MMC D Street sidewalk construction

Robert Thompson <rmt@portlandmaine.gov>
To: Helen Donaldson <hcd@portlandmaine.gov>

Tue, May 21, 2019 at 2:05 PM

VALLEY STREET & "D" STREET INTERSECTION
SCALE: 1"=10'

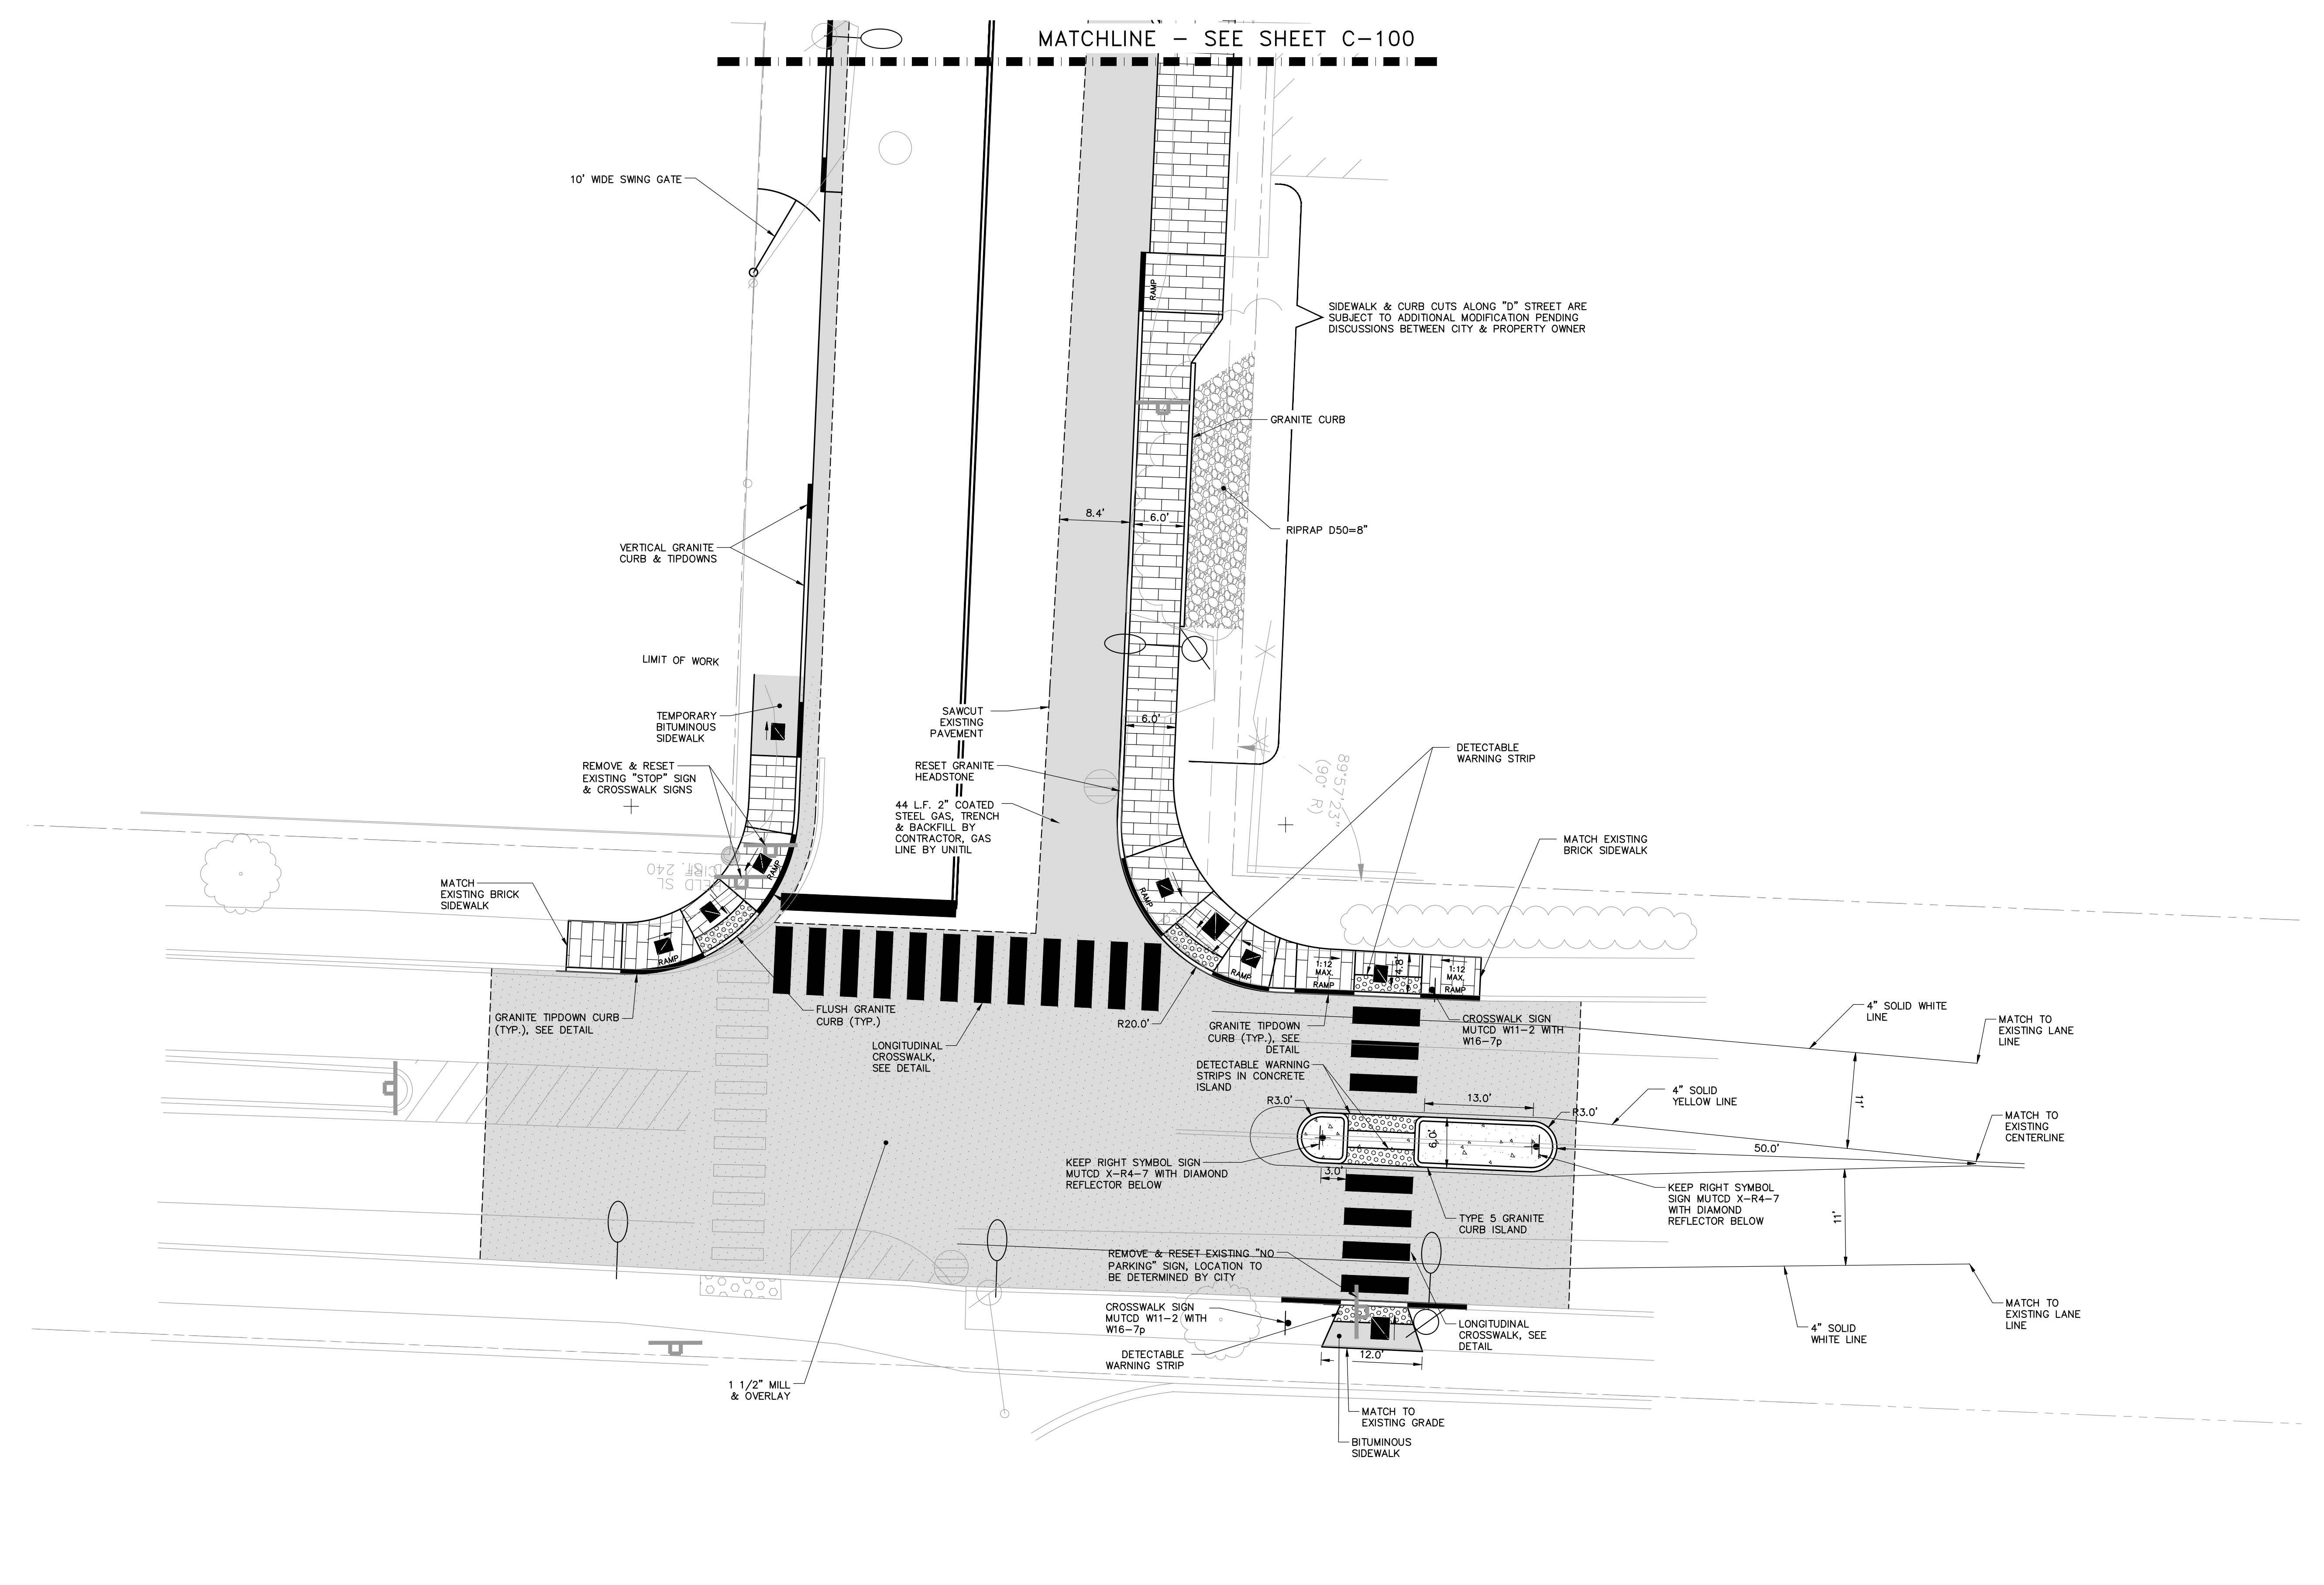
2) Though this may just be how it appears on the site plan, the proposed concrete island on Valley Street appears to encroach on the curb cut for D Street. Doing so will create a difficult left turn from D onto Valley Street, especially for commercial vehicles. The existing island sits about 45' back from the intersection to aid in commercial vehicle movement, coming into and out of D Street. I'm don't believe a fire truck can make that turn.
